Viking CCS Pipeline

9.6 Design Changes 1 and 2: Environmental Technical Note

Document Reference: EN070008/EXAM/9.6

Applicant: Chrysaor Production (U.K.) Limited,
a Harbour Energy Company
PINS Reference: EN070008
Planning Act 2008 (as amended)
The Infrastructure Planning (Applications: Prescribed Forms
and Procedure) Regulations 2009 - Regulation 5(2)(q)
Date: March 2024

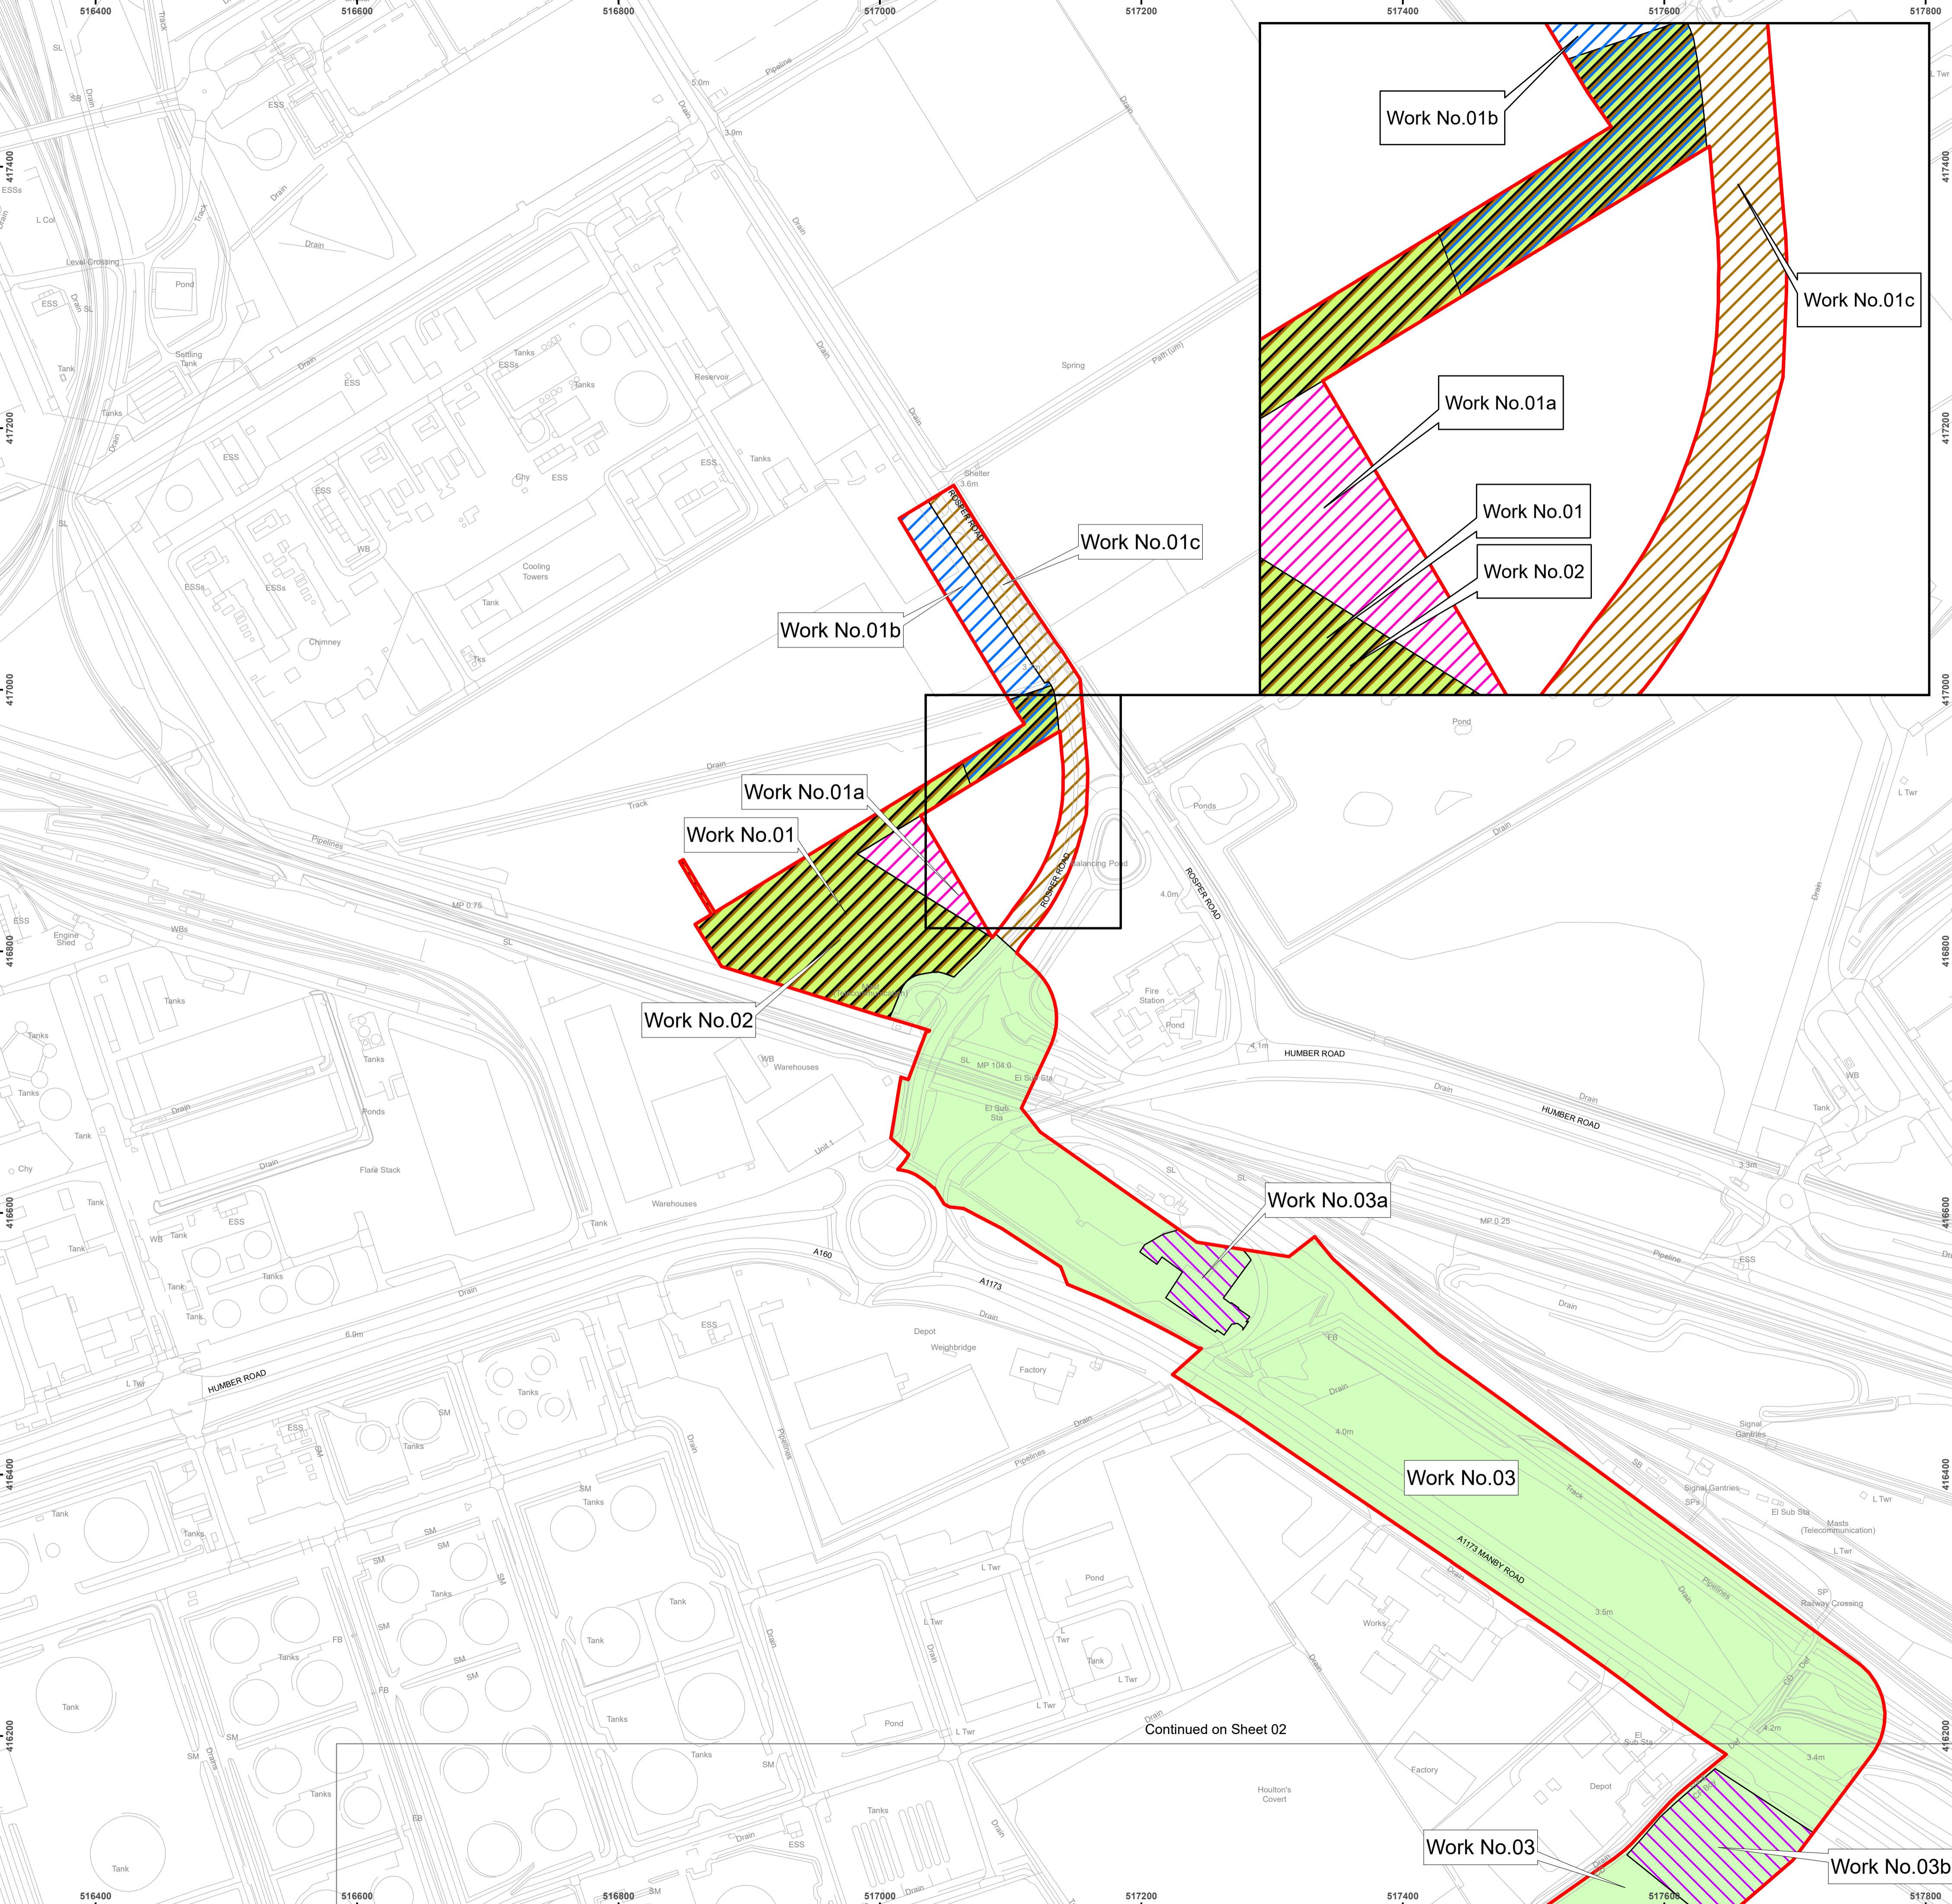
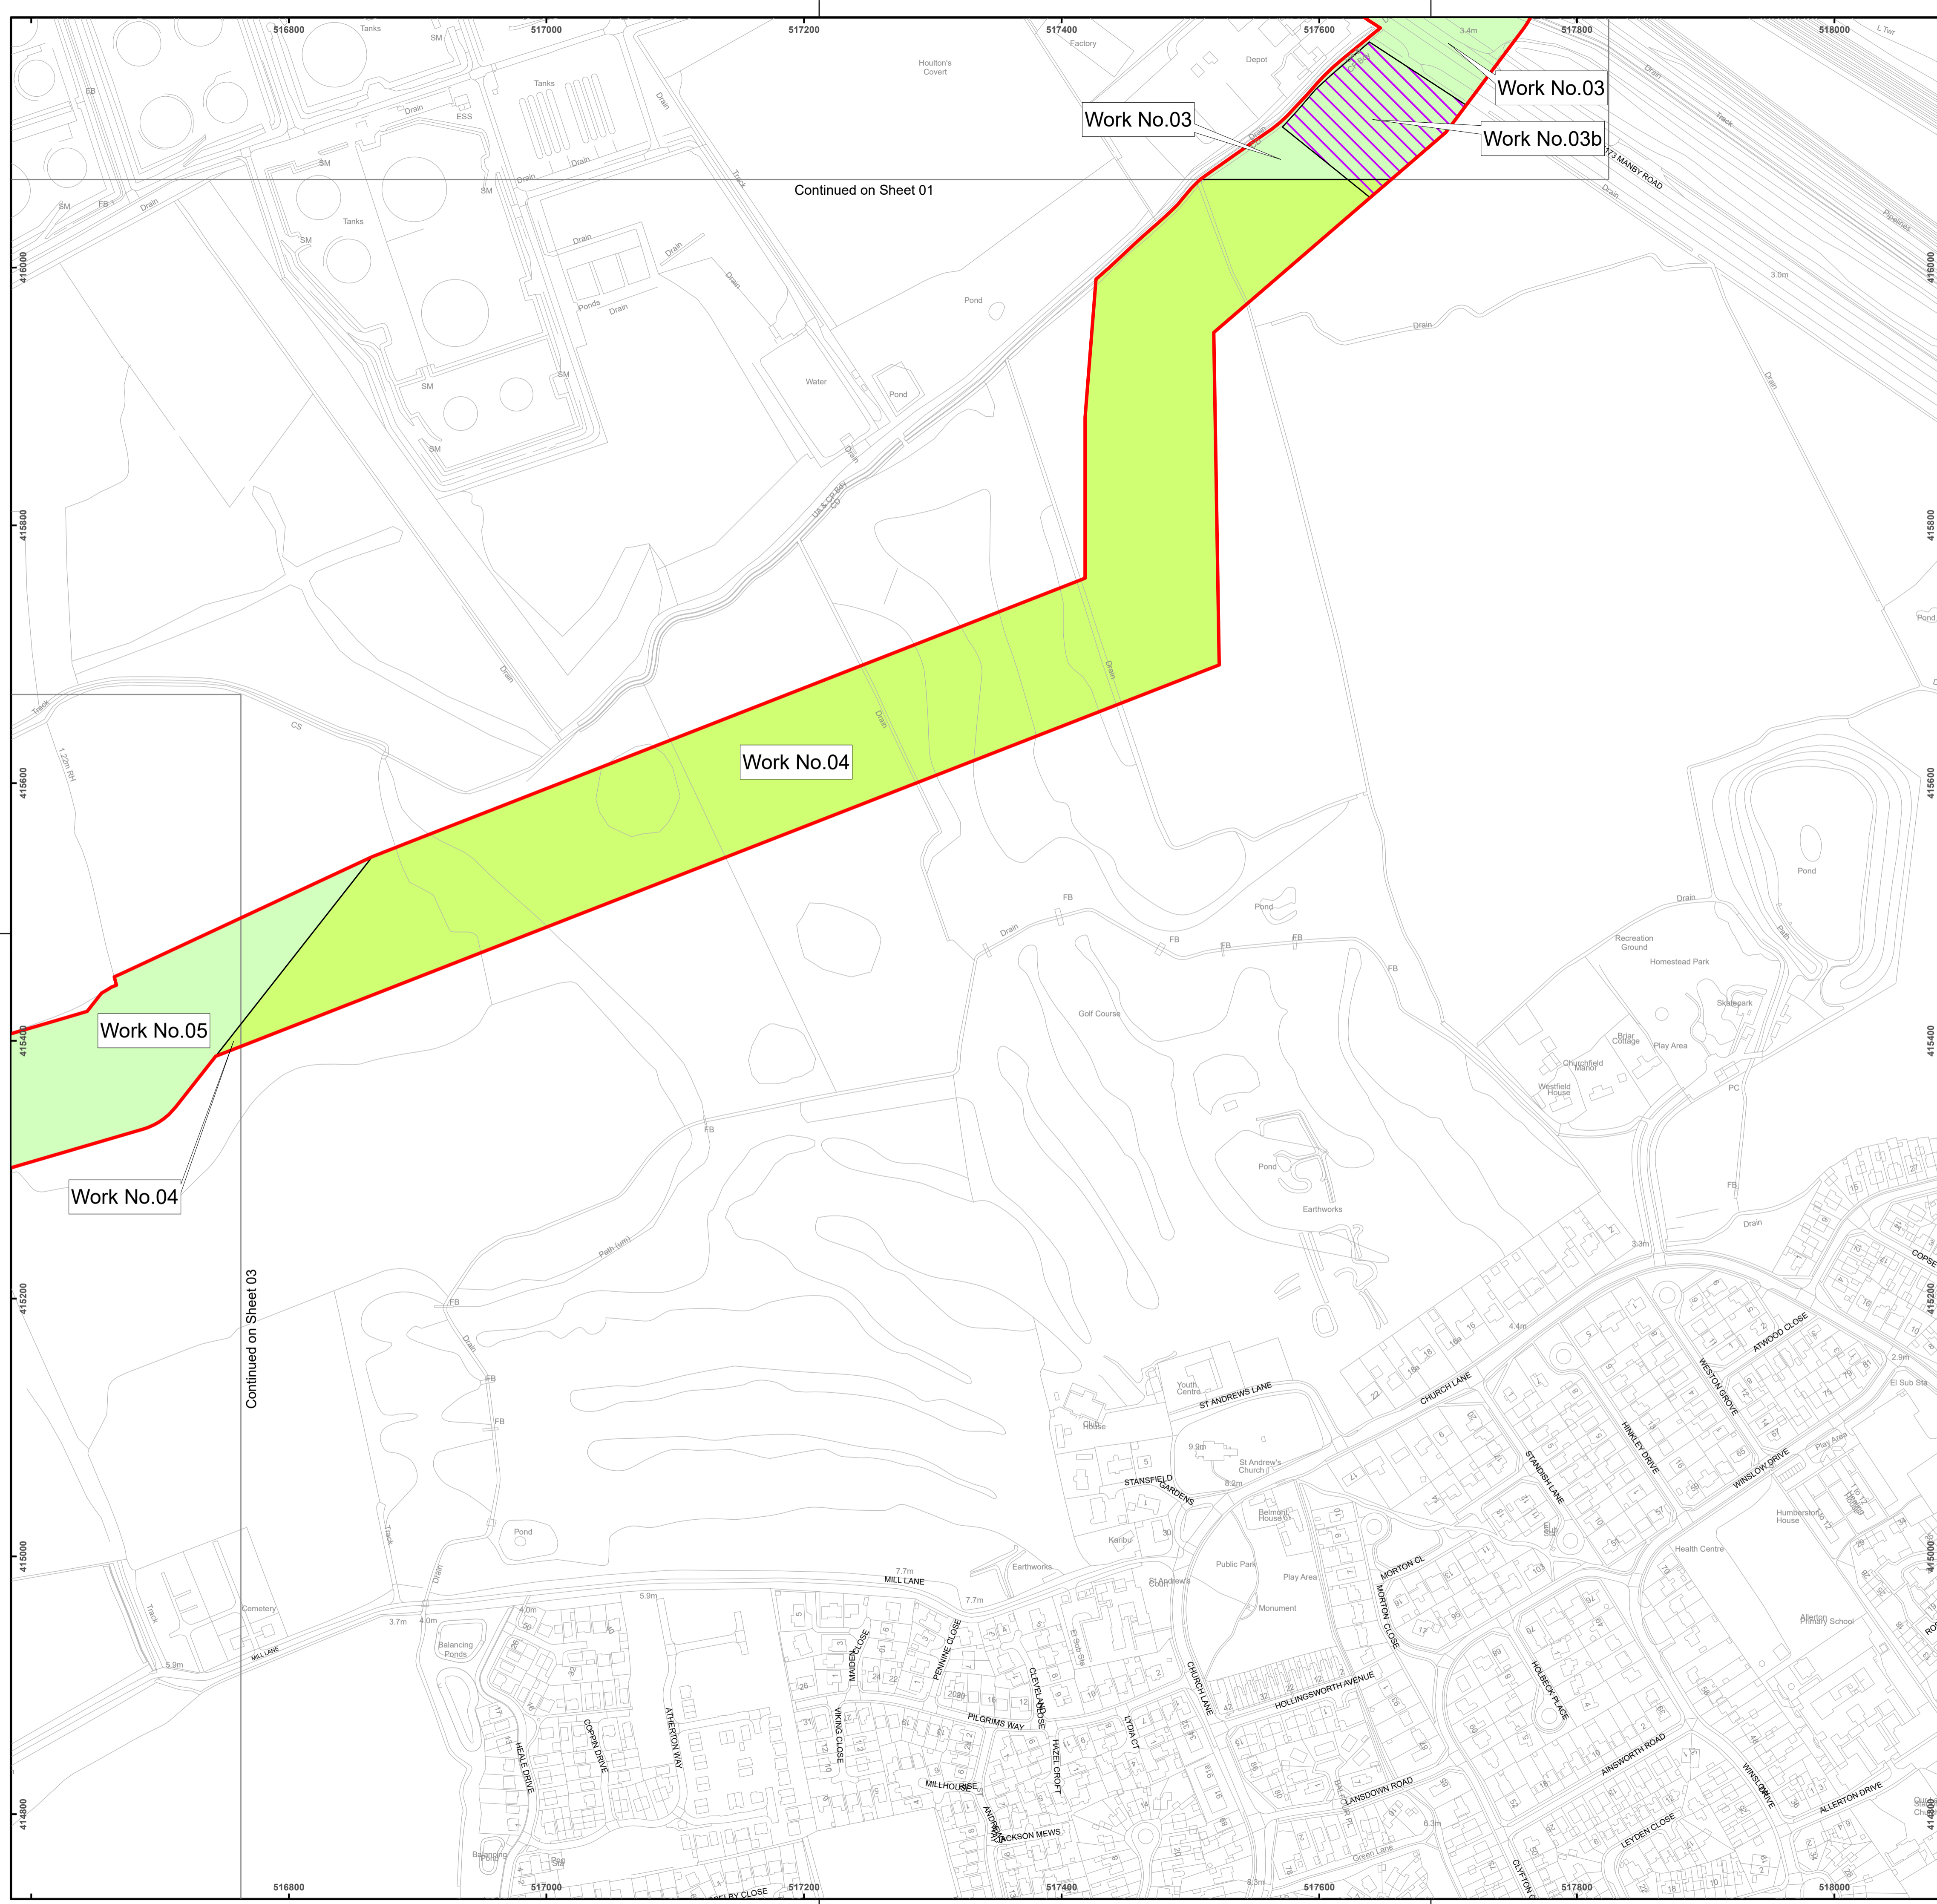
- *Design Change 1*: Modification and reduction of the Order Limits as shown on workplans Work No.01 (Permanent AGI Construction Works), Work No.01a (Permanent AGI Construction Works and Temporary Working Area), Work No.01b (Temporary and Permanent Access) and Work No.01c (Electrical Connection).
- *Design Change 2*: Removal of Work No.2 (Carbon Dioxide Pipeline Works), Work No.02a (Temporary Access & Laydown Location) and Work No.02b (Temporary Access & Laydown Location).

2.2.3 This change would result in reductions to the Order Limits as shown in **Figure 1**. No additional land outside of the current Order Limits is required. The reduction in the area of the Order Limits for Design Change 1 totals 2.55 hectares.

2.3.3 This change therefore involves a reduction in the Order Limits and would thus reduce the area of land included in the Order Limits, as shown in **Figure 2**. The reduction in the area of the Order Limits for Design Change 2 totals 16.06 hectares. This change would also remove two temporary access and laydown areas which would no longer be needed. Consequently, this change also means that it is confirmed that the pipeline will exit the Immingham Facility using Option 1.
